M25 junction 28 improvement scheme

TR010029

9.84 Applicant's comments on Transport for London's response to ExAWQ2

April 2021

Maritime House, Basin Road North, Portslade, Brighton, BN41 1WR  
Telephone: 01273 414515      www.redwoodpartnership.co.uk

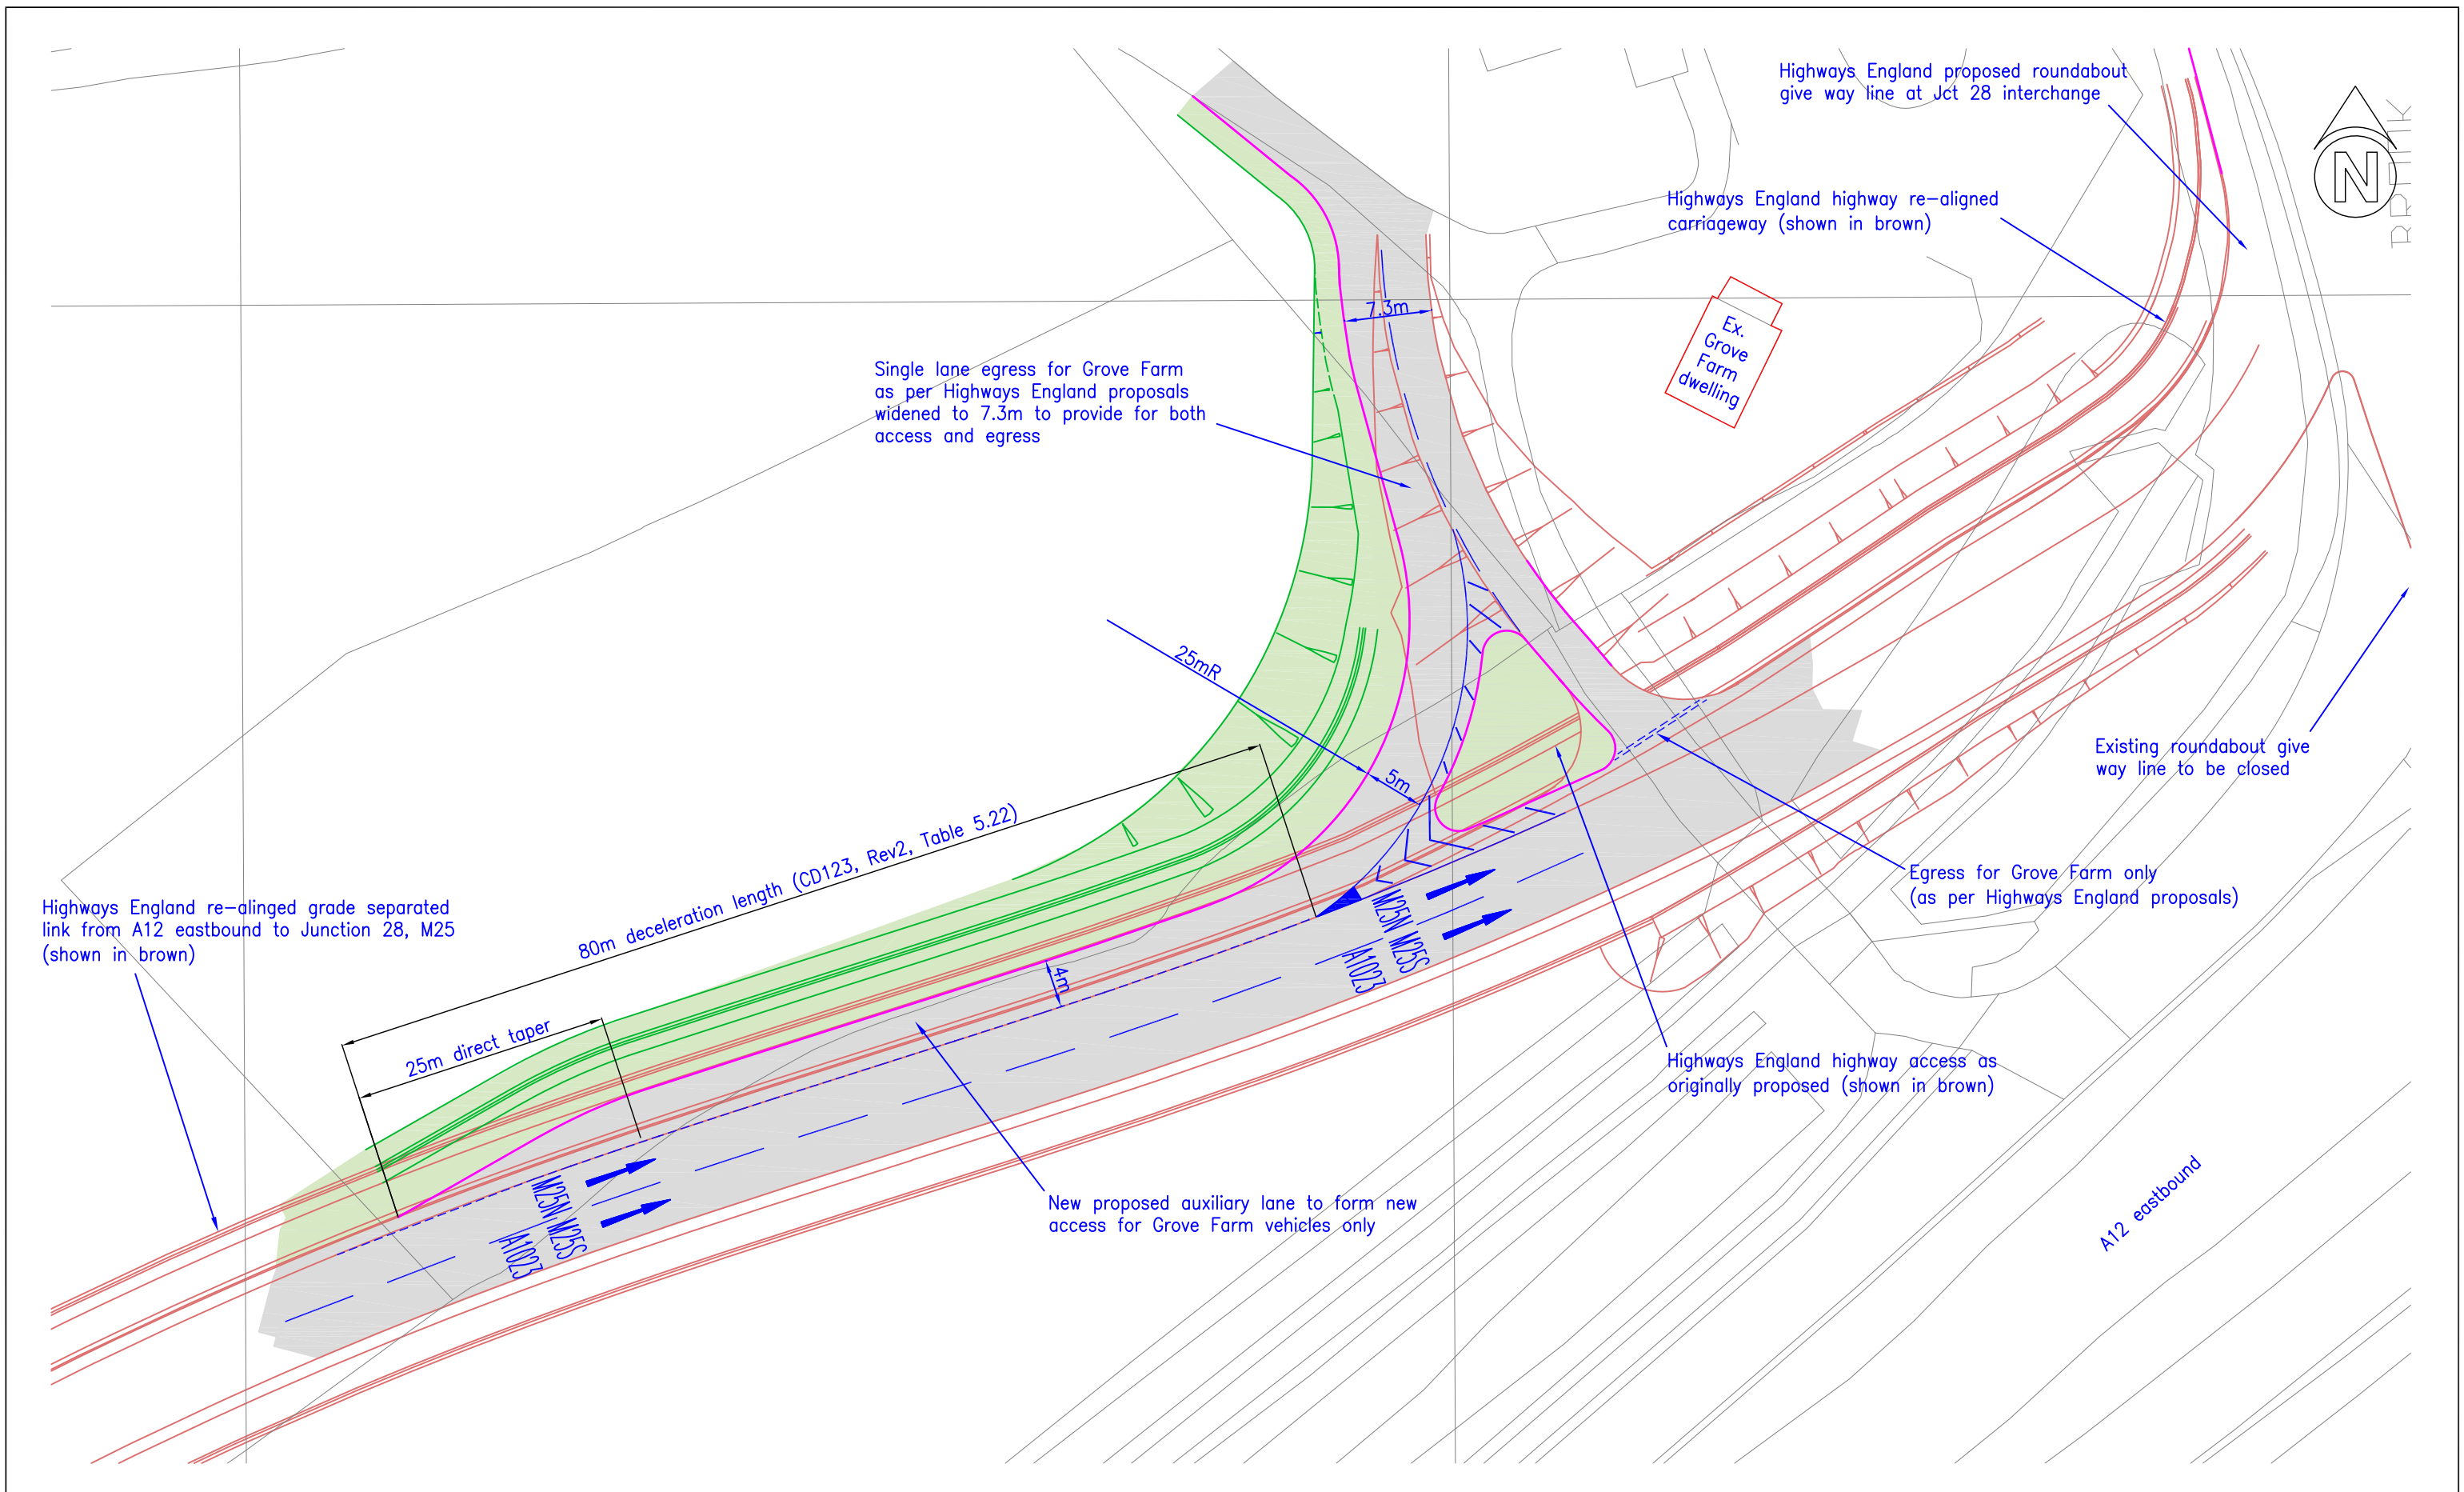
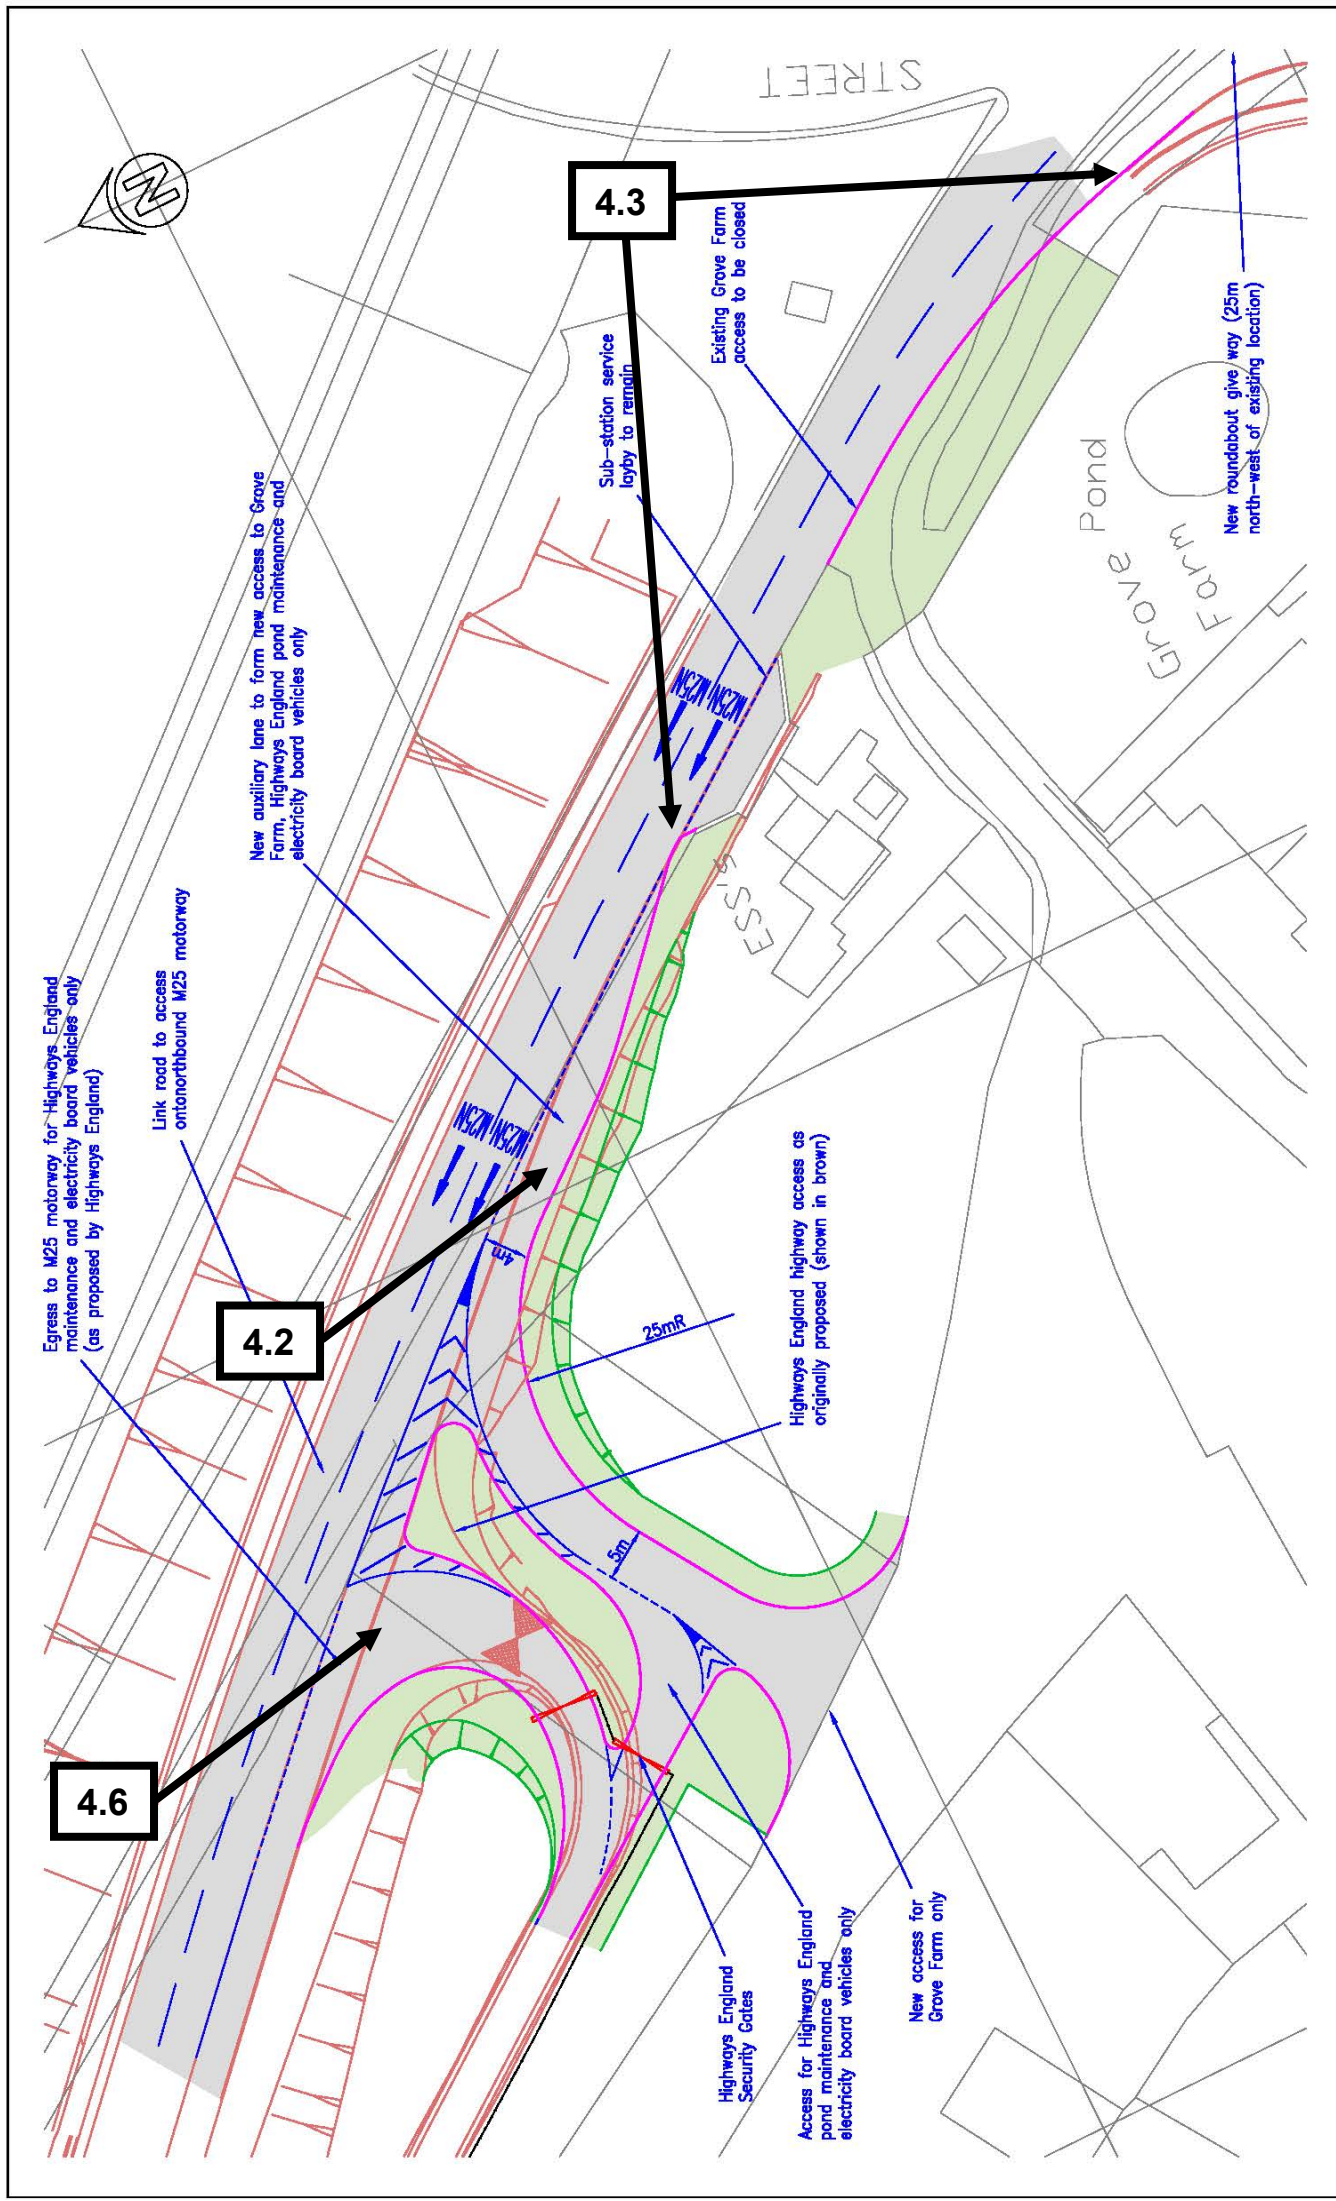
TA 2.3 Proposed Access / Egress at Grove Farm The Applicant Transport for London London Borough of Havering	The representatives of Mr & Mrs Jones submitted revised proposals at Deadline 4 [REP4-036] for access / egress to and from their property. Provide comments on these proposals.	TfL has reviewed the proposed new Location for the egress from Grove Farm onto the new A12 eastbound off slip road set out in the plan in document REP4-036. This results in the egress being Located approximately 120 metres from the proposed stop Line at the roundabout instead of the current distance of approximately 70 metres, an increase of 50 metres. TfL has not identified any immediate safety concerns with this proposal when compared with the Layout currently proposed by the Applicant. It would be important to demonstrate that there is sufficient visibility to and from the new egress Location for the required design speed. The alternative egress Location may require a new or revised departure from standards. TfL is not able to comment on the proposal in terms of construction feasibility or environmental impacts and we would expect the Applicant to consider these alongside a full assessment of road safety implications.	Noted
